East Lindsey District Council Response to ExA Rule 17 Request for Further Information

Planning Act 2008 (as amended) (PA2008) – and The Infrastructure Planning (Examination Procedure) Rules 2010 (as amended) – Rule 17 Application by Chrysaor Production (UK) Limited for an Order Granting Development Consent for the Viking Carbon Capture and Storage (CCS) Pipeline Request for Further Information

Drawing title
**Central Construction Compound
Regulation 5.2 (o)
Application Document Reference 4.10
(Sheet 1 of 1)**

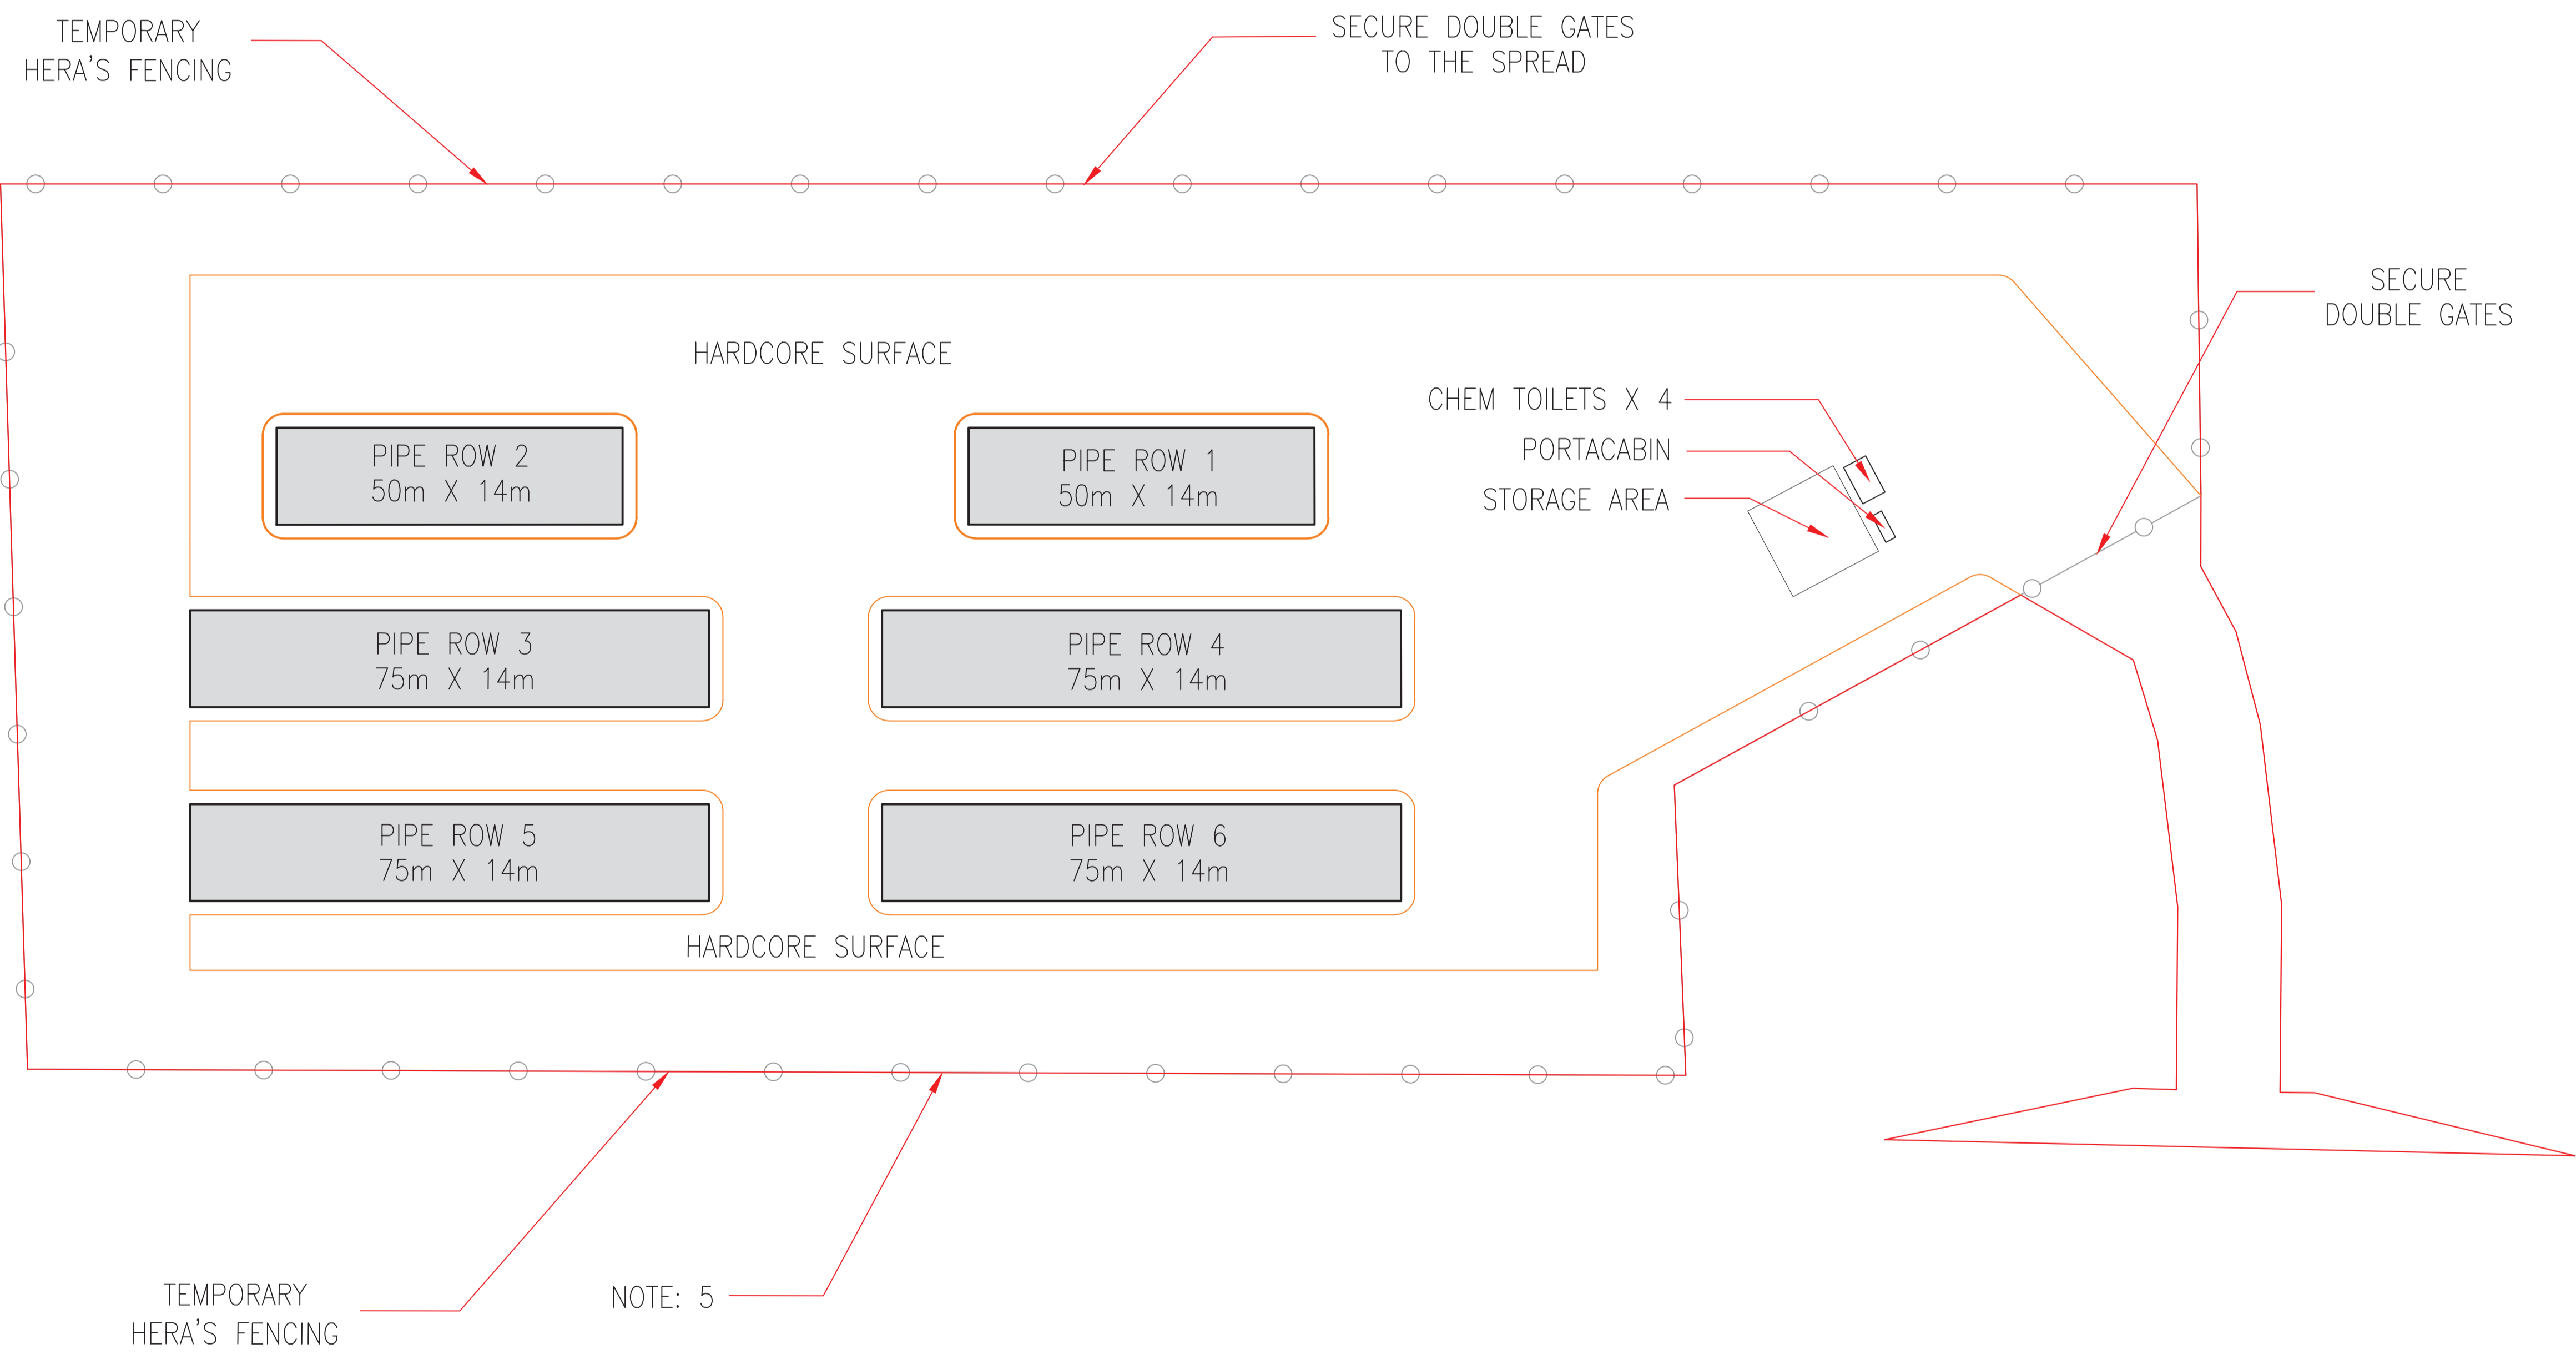
With respect to fuel consumption, no information is provided for fuel use from on-site generators at the construction compounds (Table 15-25 of Chapter 15 on Climate Change).
